Application number: 2024/62/93294/W	
What is the application for?:	Erection of two storey side and single storey rear extensions
Address of the site or building:	43, Leafield Avenue, Longwood, Huddersfield, HD3 4TW
Postcode:	HD3 4TW

Proposed Elevations

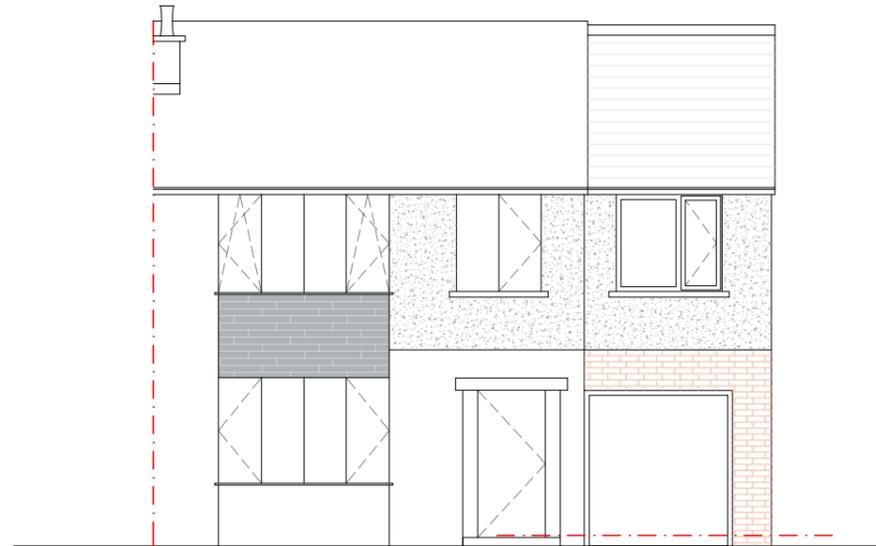
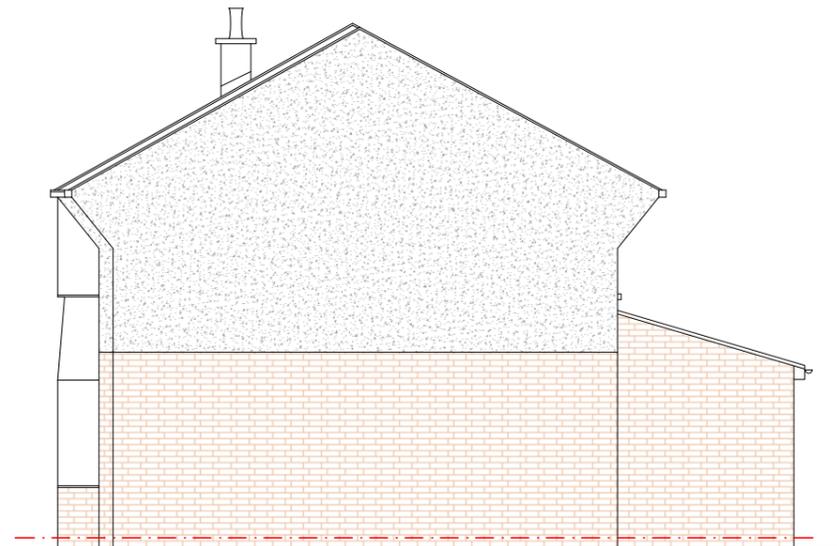
Type of comment: A general comment	
Do you wish your comments to be published on the website anonymously?	Yes
Re: Effect on a neighbouring property regarding the rear single story extension.  A request that you examine the measurements/location on the proximity of the new wall of this rear extension down the side next to the attached neighbouring 'semi-detached' house is not going to be built on the actual boundary line and that it will as the plans show step back within their own land and will not affect the existing dividing garden wall? If it were to be on the actual boundary line then we would OBJECT as it would affect the opportunity for our property to have a similar maximum width extension in the future.
